**PLANNING ACT 2008
APPLICATION BY HIGHWAYS ENGLAND FOR AN ORDER GRANTING
DEVELOPMENT CONSENT FOR THE A303 SPARKFORD TO ILCHESTER
DUALLING
SUBMISSION MADE PURSUANT TO DEADLINE 8**

PLANNING INSPECTORATE REFERENCE TR010036

Deadline 8 – SCC response to Action Point 17 (from 23 May) and response to the Applicant’s comments on Action Point 64 (from 14 & 15 May) issued at Deadline 7

**WORK NO 5
(PODIMORE TURNING HEAD)**

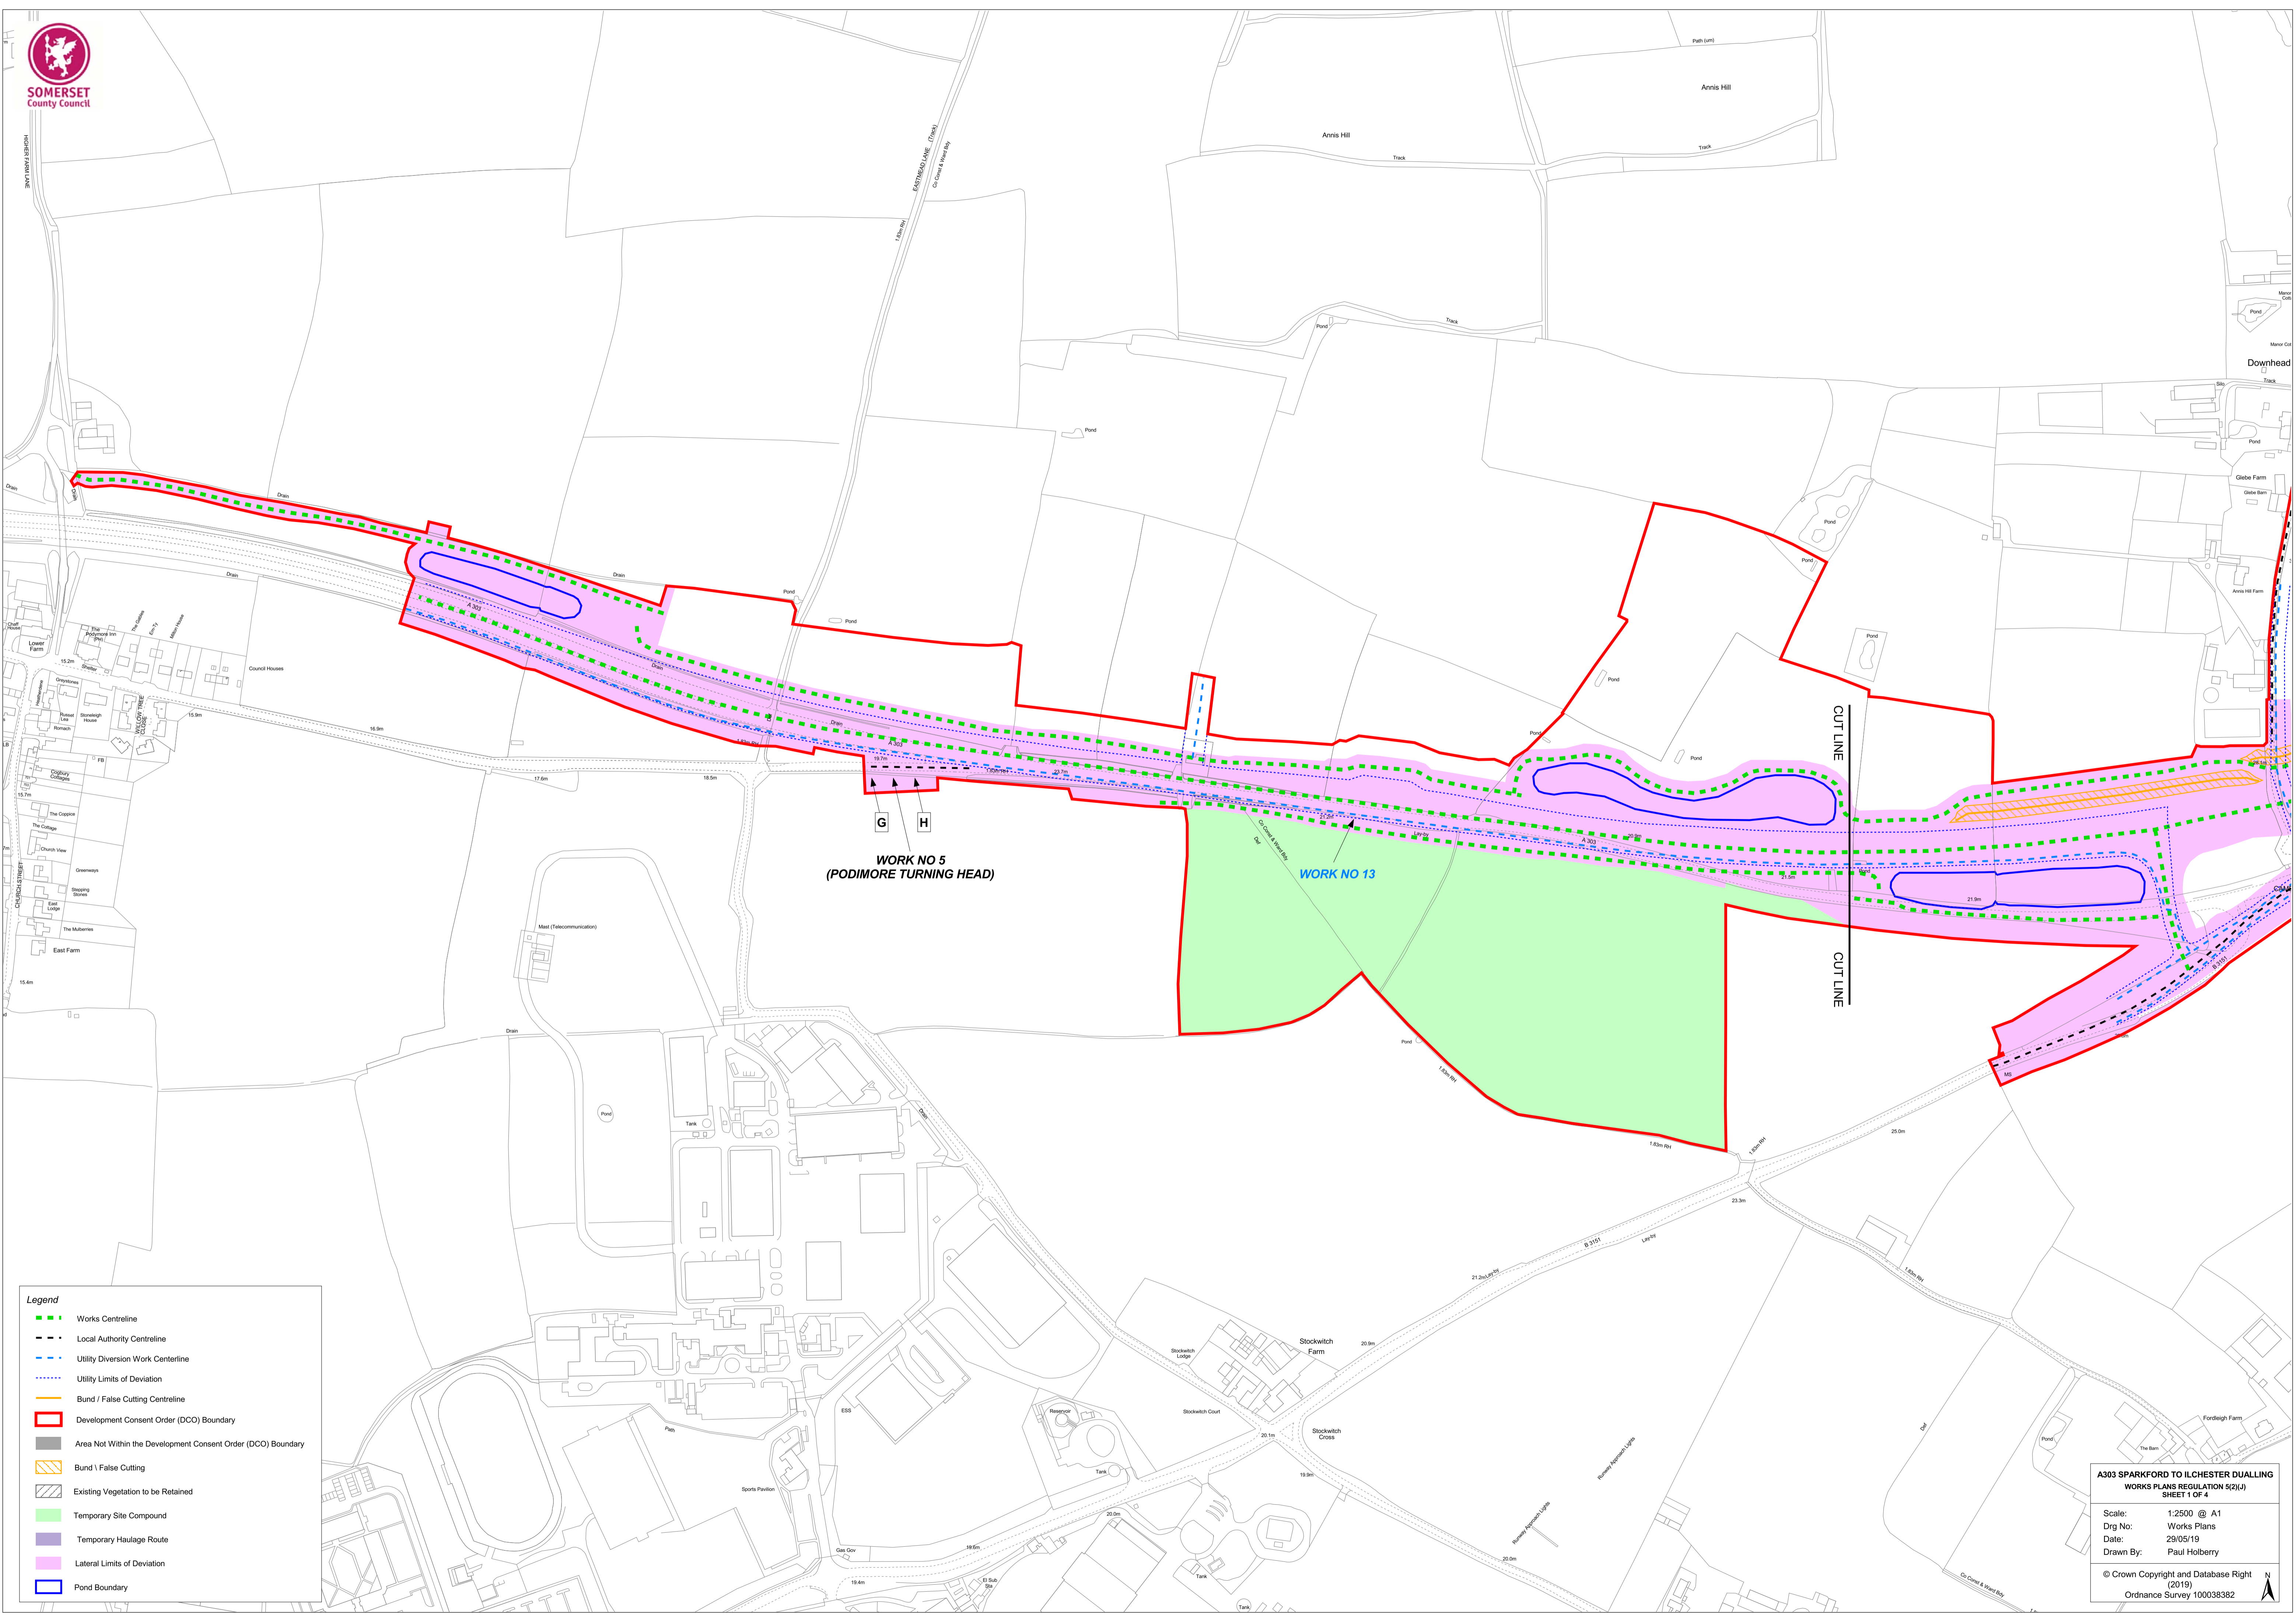
In addition to the two items above, during the course of the Examination SCC and Highways England entered into discussion in relation to the Podimore Turning Head.

SCC was concerned that the proposed scheme would include a piece of road from the T junction along the Podimore Off Slip serving no purpose. There are no agricultural accesses along this stretch and it would also not serve private properties; the road could not be accessed from the A303 as its being stopped, and vehicular

movements cannot legally be made eastwards towards the A303 as it is currently one-way. There is also the concern that the section of road could be used for anti-social behaviour and unauthorised traveller encampments.

We therefore welcomed discussions with the Applicant in relation to the removal of the turning head, and also understood that the section of road between the T junction and turning head would be removed by virtue of a Section 278 agreement.

In respect of the Podimore turning head, the removal of the turning head by itself does not address our concerns as the section of road between the junction and A303 also requires removal. The proposal put forward by the applicant without inclusion of the road removal leads to the potential situation where a member of the public could accidentally drive along this section of road and would then have no place to turn around and would need to reverse back onto the highway. We therefore disagree that a Section 278 is not necessary to make the scheme acceptable in planning terms, as we consider that if these measures are not secured the proposed scheme could create safety issues on the local highway. The National Policy Statement for National Networks places great emphasis on safety, notably providing at paragraph 4.66 that the Secretary of State should not grant development consent unless satisfied that all reasonable steps have been taken and will be taken to:
